**Consultation Response from KC,
 Lead Local Flood Authority**

2020/93308 Former Spotted Cow Pub, New Hey Road, Huddersfield, HD3 4BU

Erection of an A1 foodstore with associated parking, servicing areas and landscaping

**Date Responded: 5th
 November 2020**

DRAWING TITLE
Culvert Diversion
General Arrangement

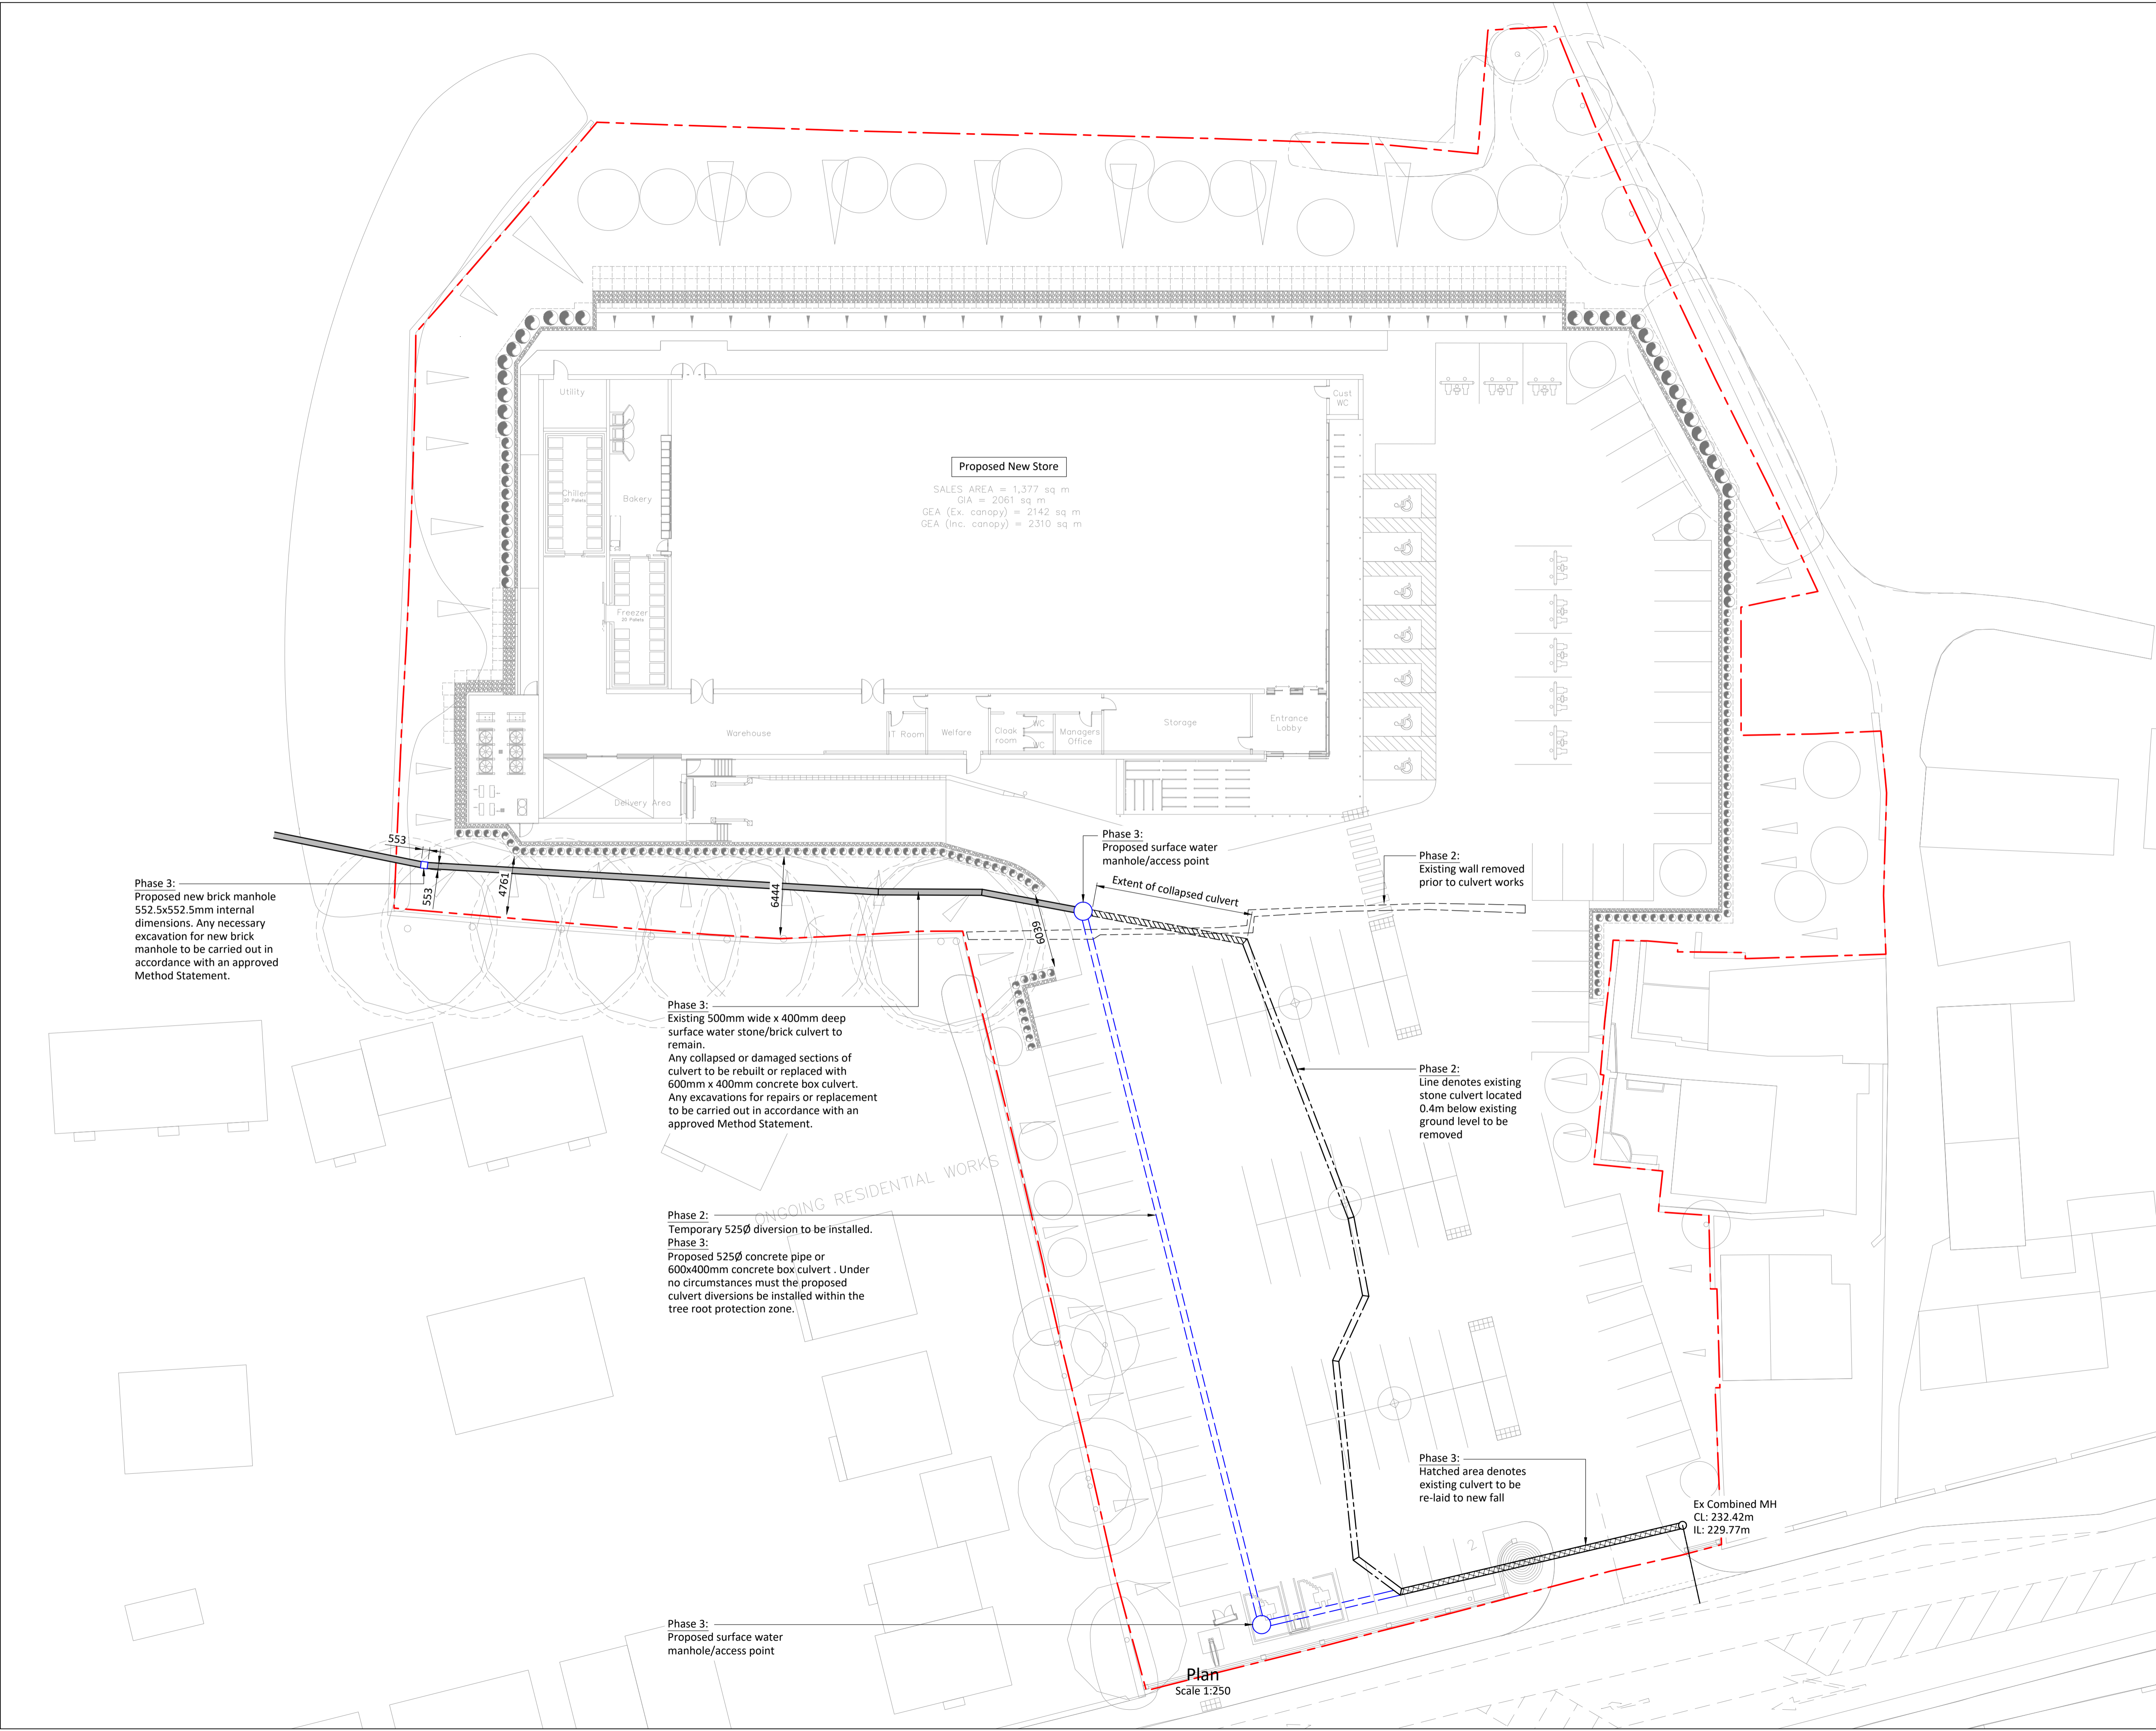
Damaged sections of the culvert will be removed as part of this scheme and an overland flow route created to manage catchment surface water flood risk identified on surface water flood risk plans.

It is noted that tree roots of protected trees may affect the area where the existing culvert enters site. Should the culvert be damaged through the construction process, for example sheet and contiguous piling to created retaining walls then there is an obligation for the landowner to repair or replace said culvert under riparian ownership rights and responsibilities.

It is notes however that invert levels of existing drainage still must be confirmed and no Microdrainage statistics have been provided with this current application. These will be required.

We would like, where reasonably practicable, to reduce severe changes in direction for the diverted culvert (90 degree bends) in order not to lose flow energy and present an improvement in hydraulics.
